**Town & Country Planning Act 1990 (as amended)
Town and Country Planning (Development Management Procedure) (England) Order 2015
Application for Full Planning Permission**

Development Change of use of existing ground floor retail unit (B1Business) to 3 No. flats (C3 Dwelling houses).
Location Ground Floor unit Saltmarsh House Old Market Lane Littlehampton

PROPOSED GROUND FLOOR PLAN & PROPOSED ELEVATIONS

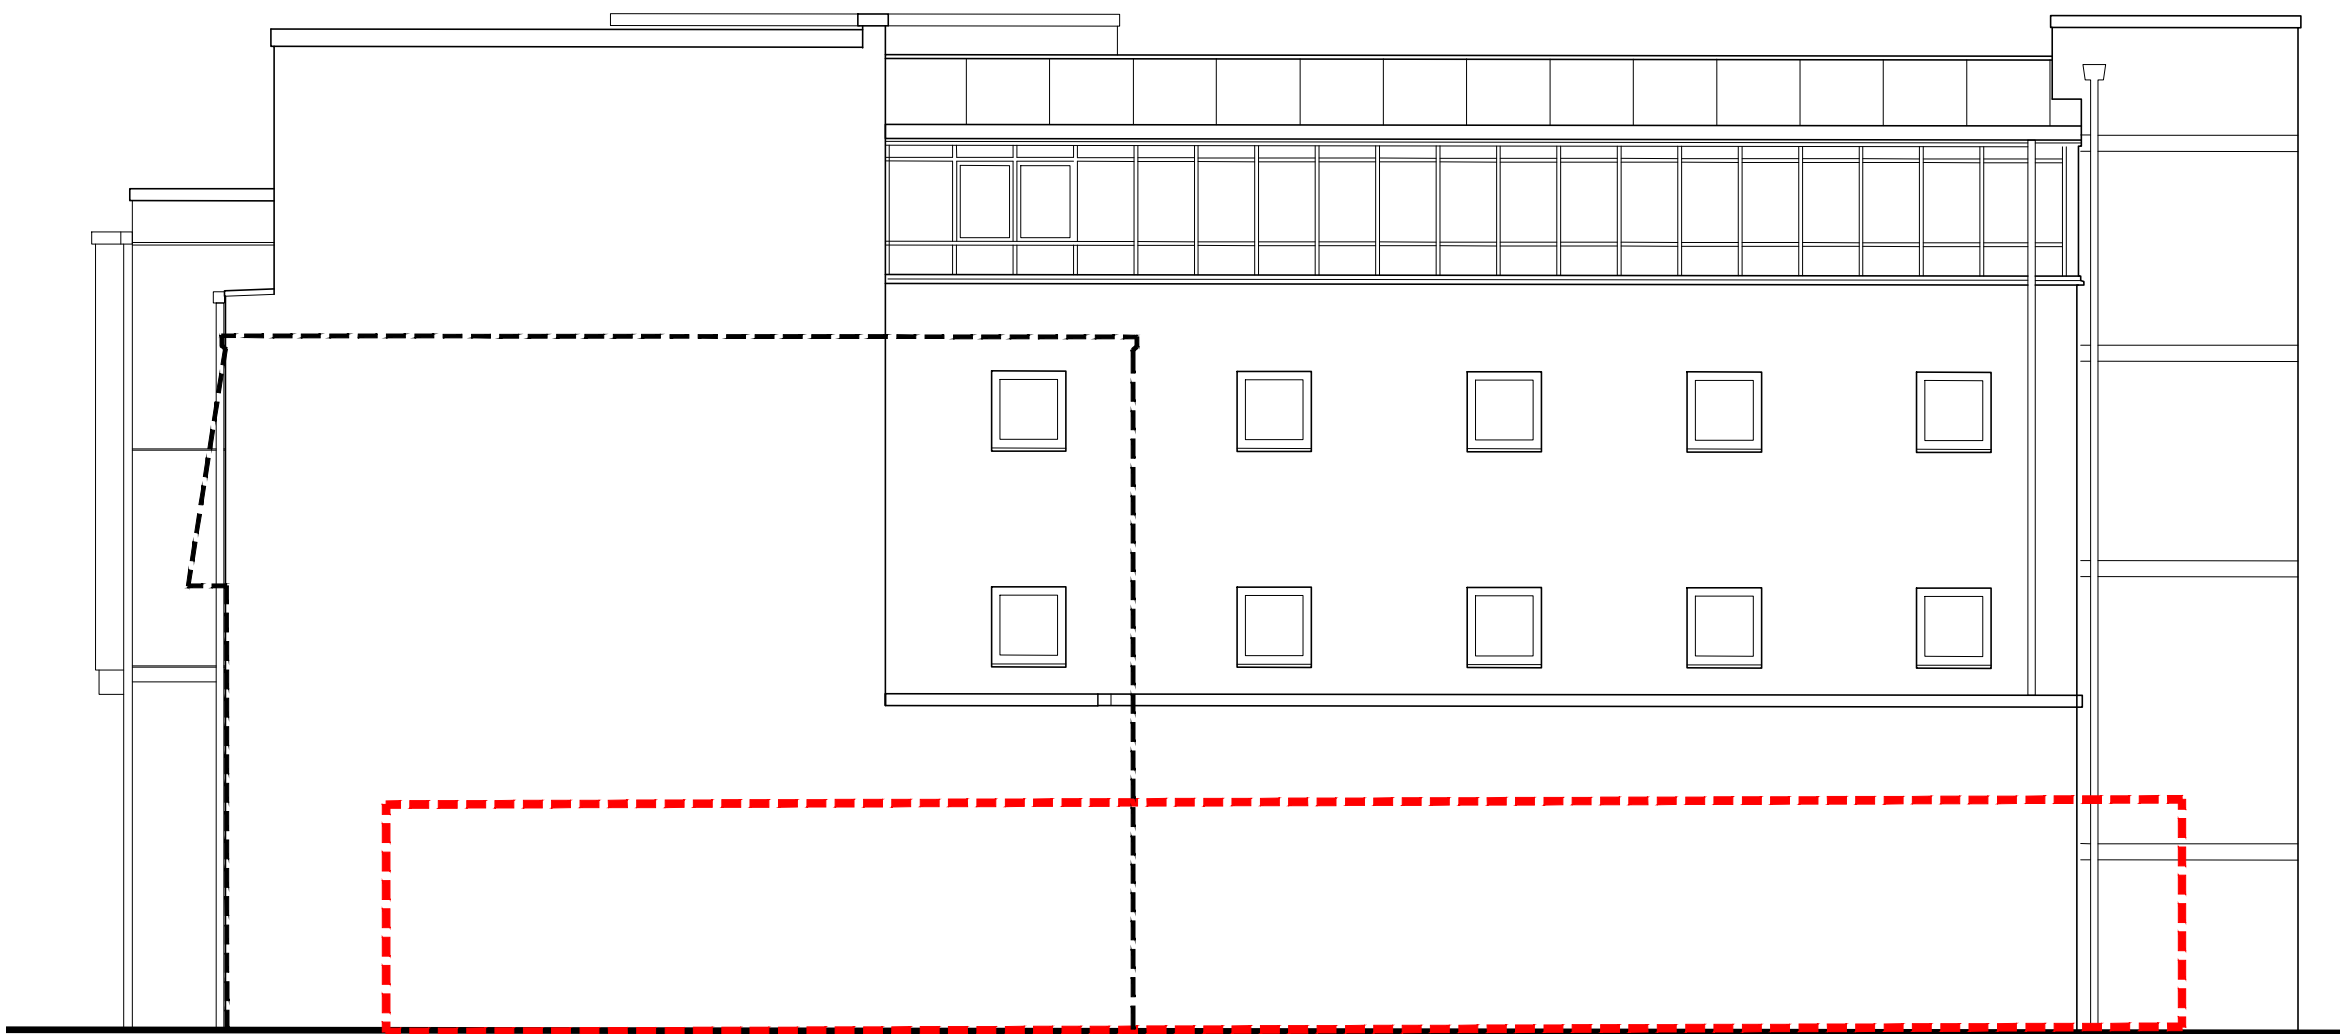
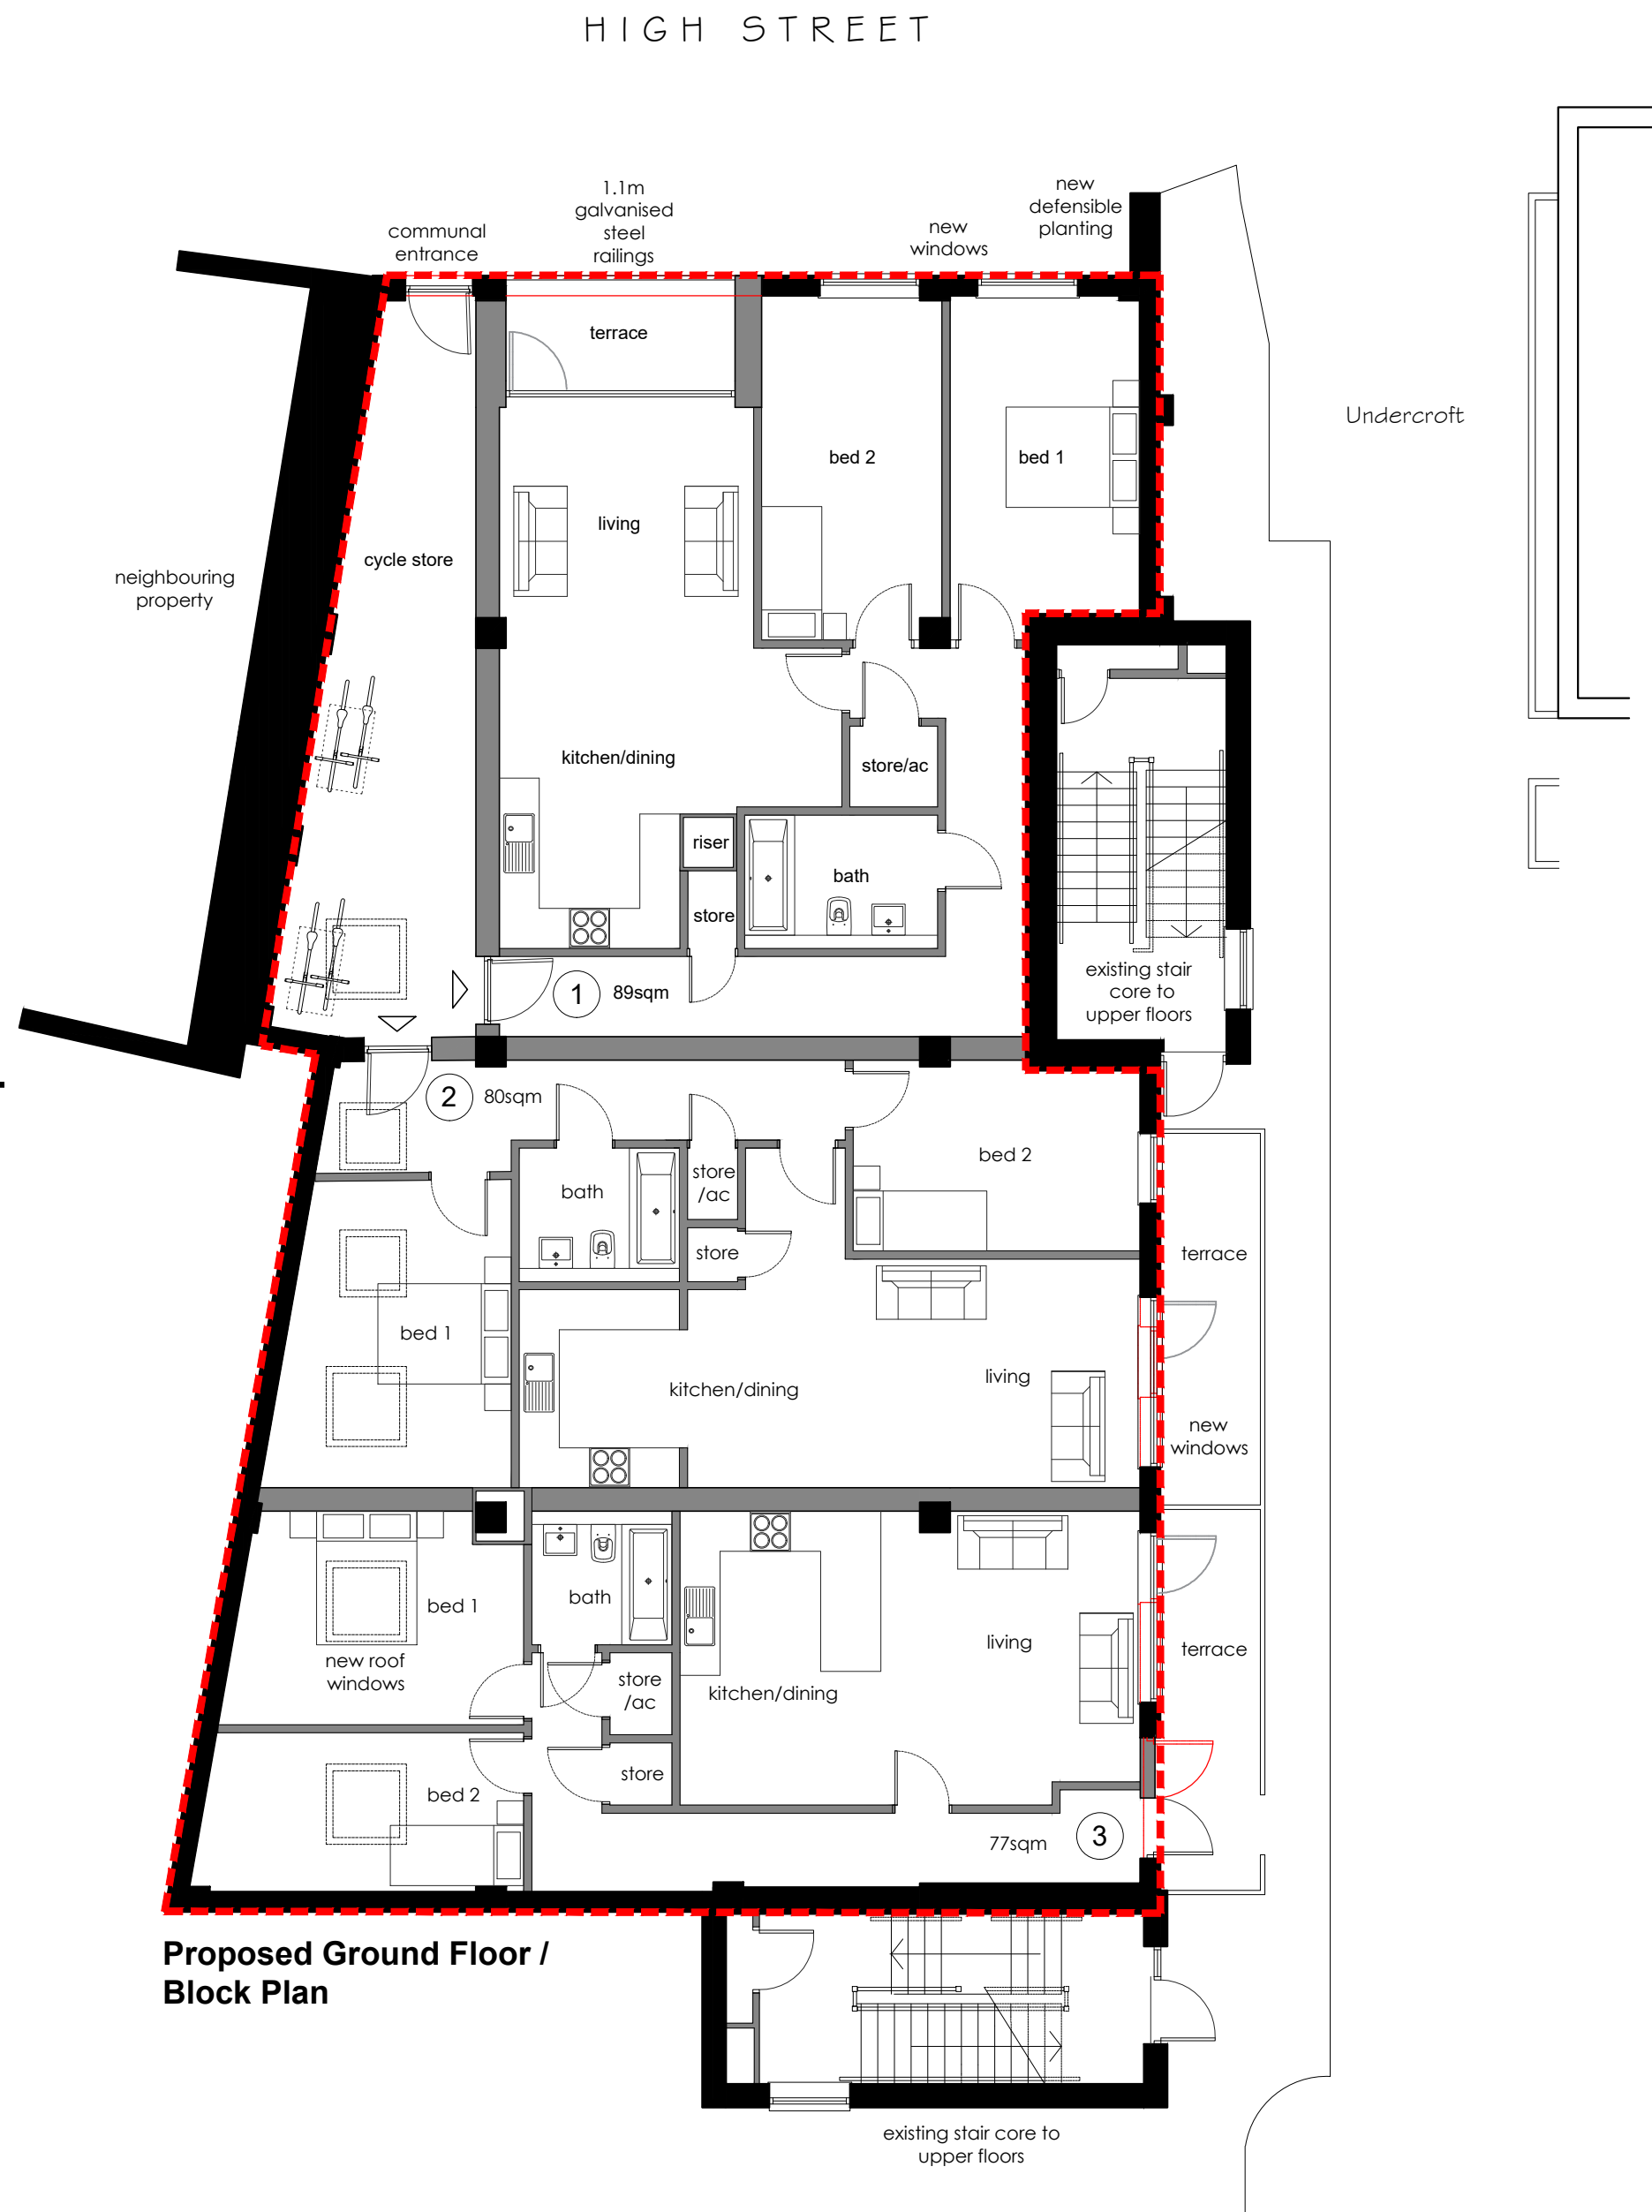
The existing and proposed ground floor plan and East elevations do not accord. Please amend accordingly.
